**Re: Design Submission for Housing Development at Crown Square Development, Monivea Road, Galway (the “Development”) (the “Design Submission”) / 953699652.**

- 183-106-051-PL1 Proposed Ground Floor Drainage Layout – Phase 2
- 183-106-053-PL1 Basement Floor Drainage – Phase 2
- 183-106-054-PL1 Watermain Layout – Phase 2
- 183-106-057-PL0 Drainage Longitudinal Sections – Sheet 3 of 6
- 183-106-058-PL0 Drainage Longitudinal Sections – Sheet 4 of 6
- 183-106-060-PL0 Drainage Longitudinal Sections – Sheet 6 of 6

PIPERUN 60 - FOUL BASEMENT LEVEL -2 - LONGITUDINAL SECTION
SCALE HORIZONTAL 1:500 VERTICAL 1:100

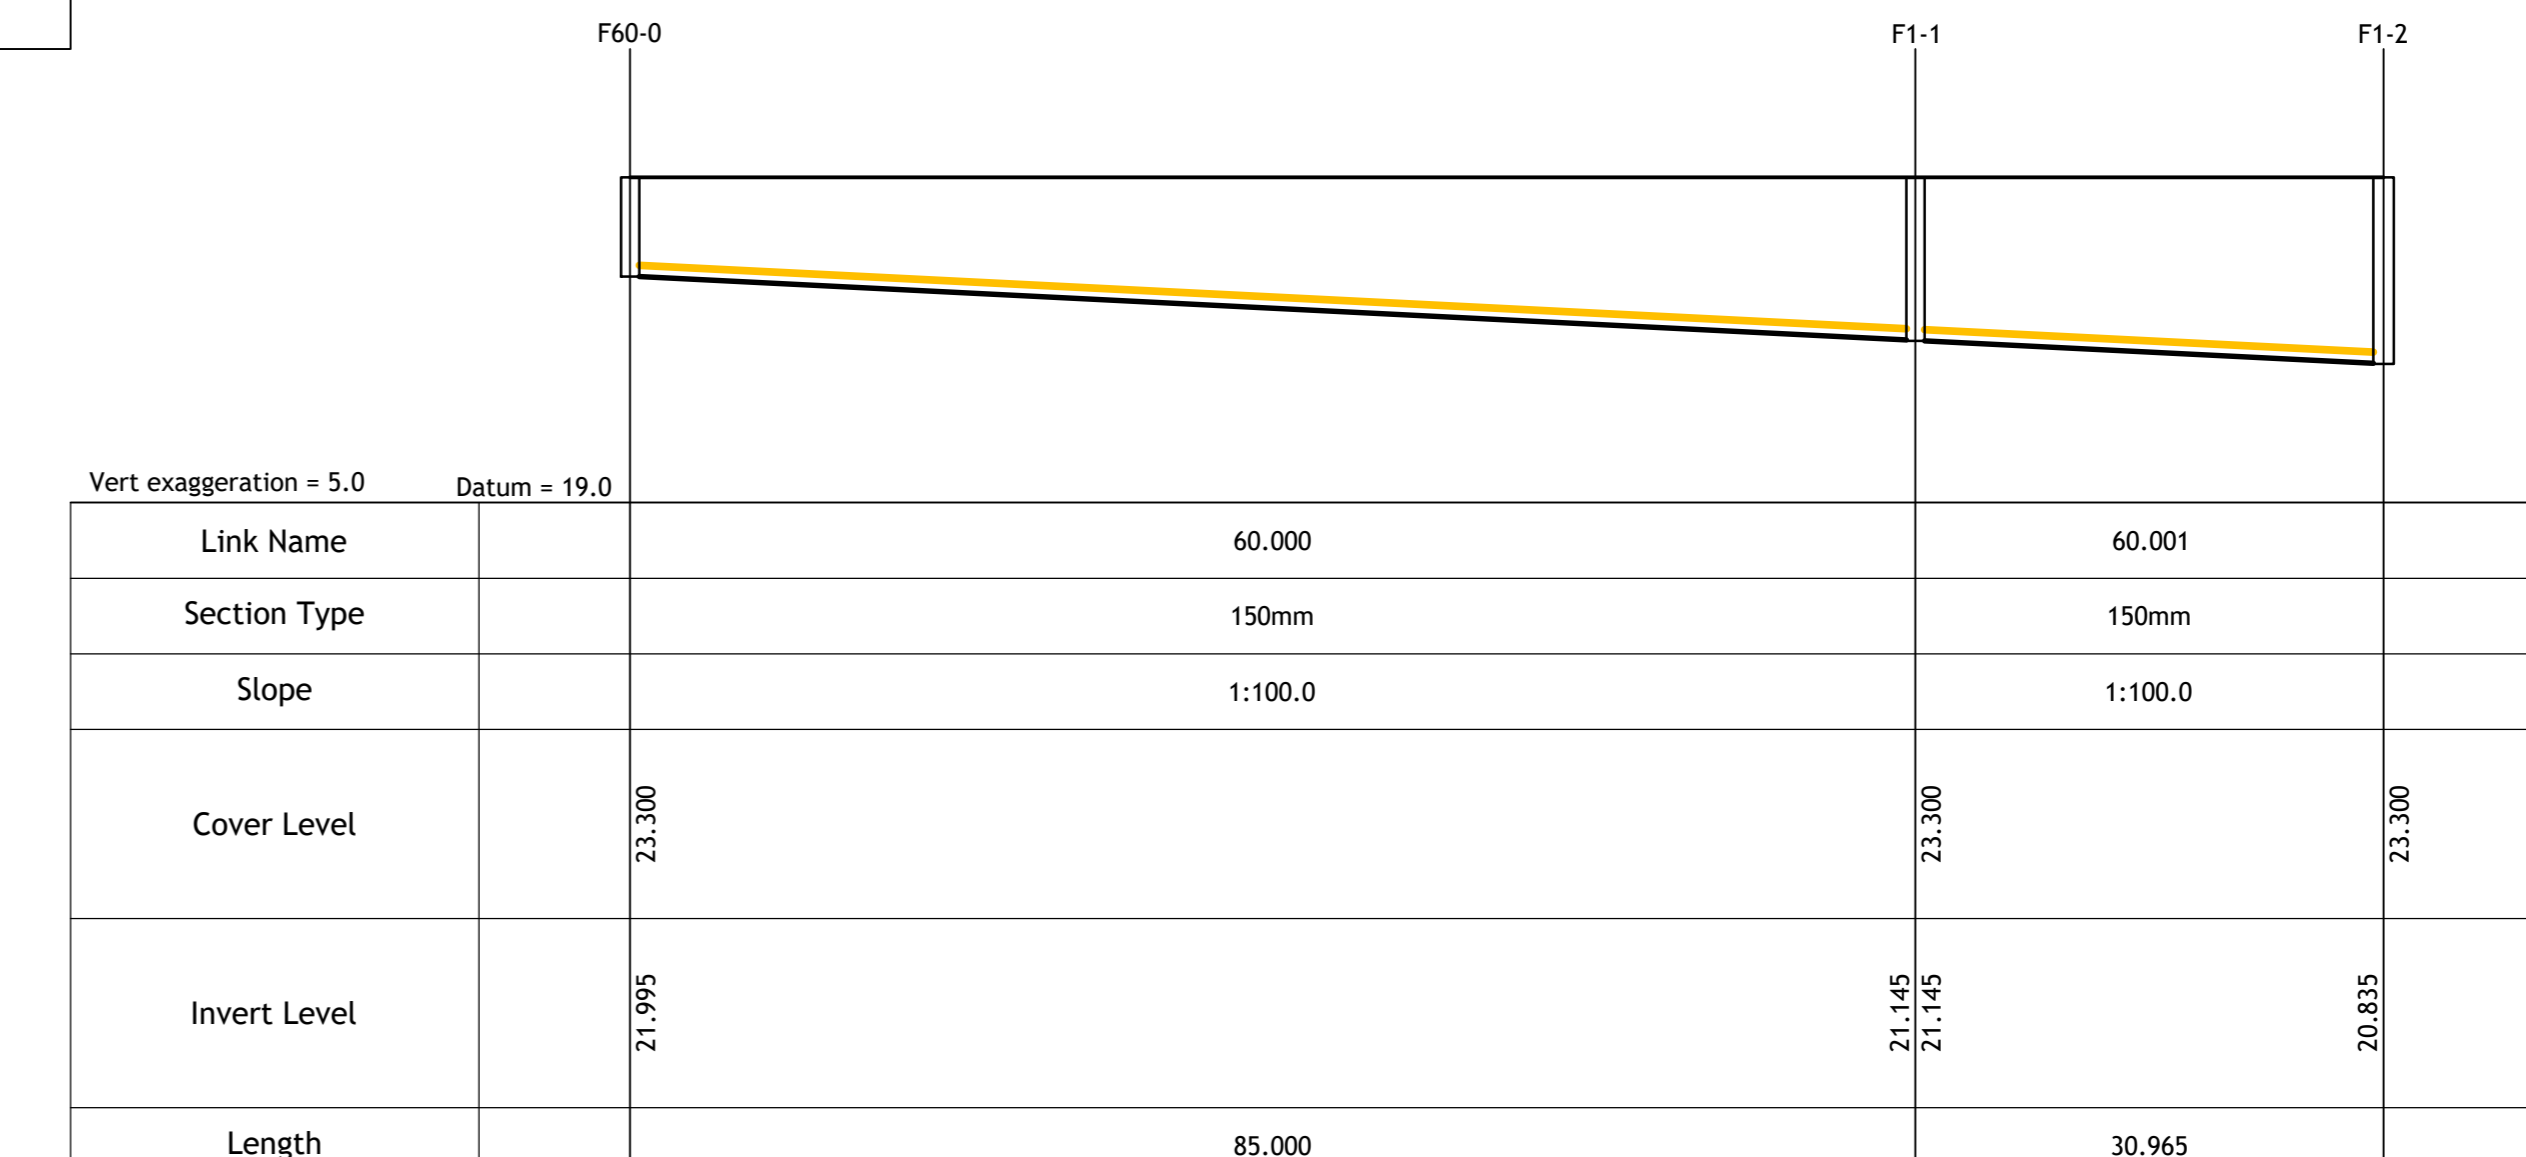
**\* Statement of Design Acceptance conditional that minimum cover to FC20-10 is increased to 500mm as per section 3.9.1 of the Wastewater Code of Practice**
